CITY OF PORTLAND

STOP WORK NOTICE

June 5, 2001

RE: Garage Construction @ 14 Torrey St.
CBL: 156-C-005

Fe Drawing
w/ house

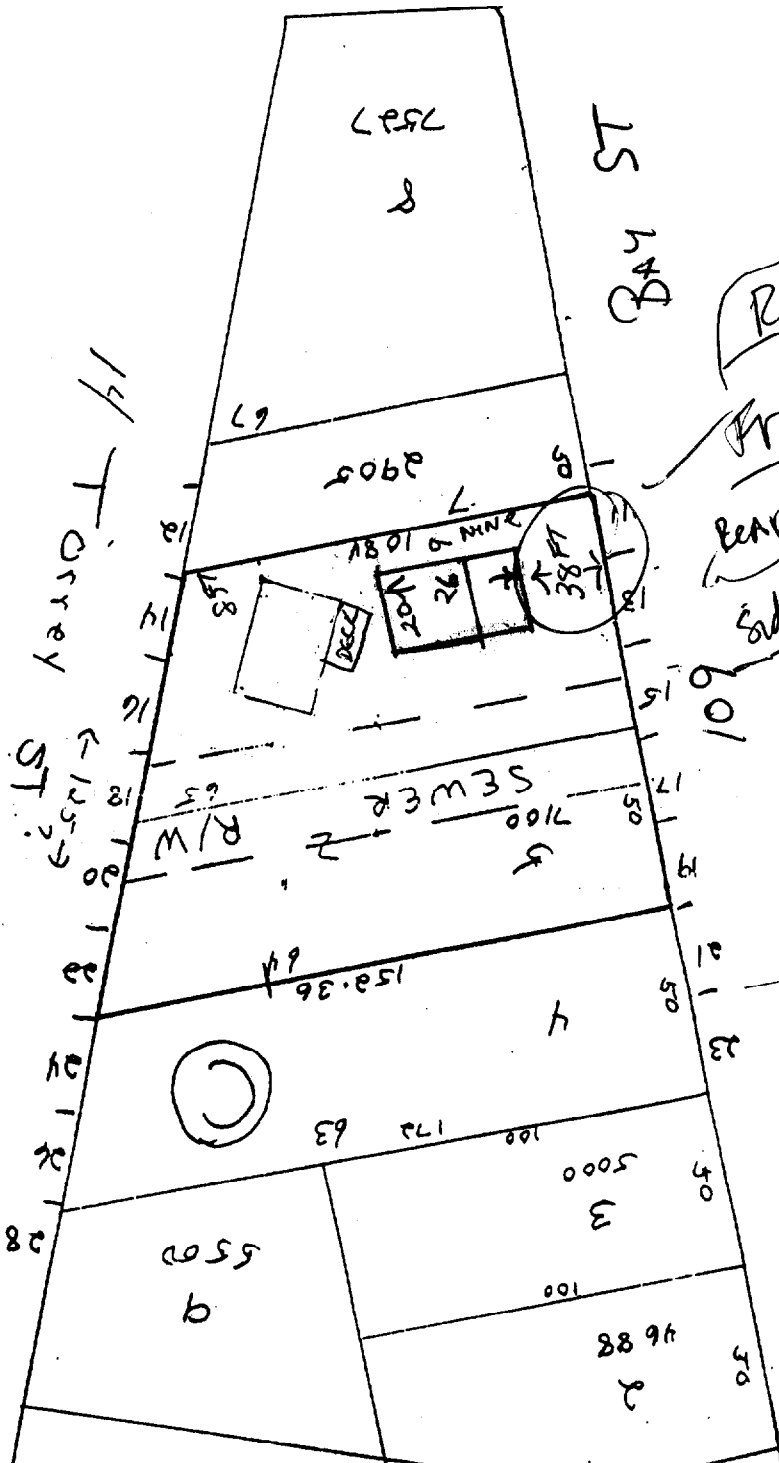
Section 111.4 Construction not meeting the site plan; measured distance to rear boundary @ 20 not 38 as shown, 25 feet required and side set back not determined due to lack of property line, 8 feet required .

Section 113.2 Not meeting required inspections, construction commenced prior to pre-construction meeting and concrete being placed prior to establishing required setback from side and rear property lines

Failure to comply will result in this office referring the matter to the City of Portland Corporation Counsel for legal action and possible civil penalties, as provided for in Section 1-15 of the Code and in Title 30-A M.R.S.A. Ss 4452. This constitutes an appealable decision pursuant to Section 121.5 of the Code. Please feel free to contact me at 874-8709, if you wish to discuss the matter or have any questions. In order to proceed with the project it will be necessary to have side and rear lot lines established by a professional land surveyor to show compliance with the zoning ordinance Of the City of Portland.
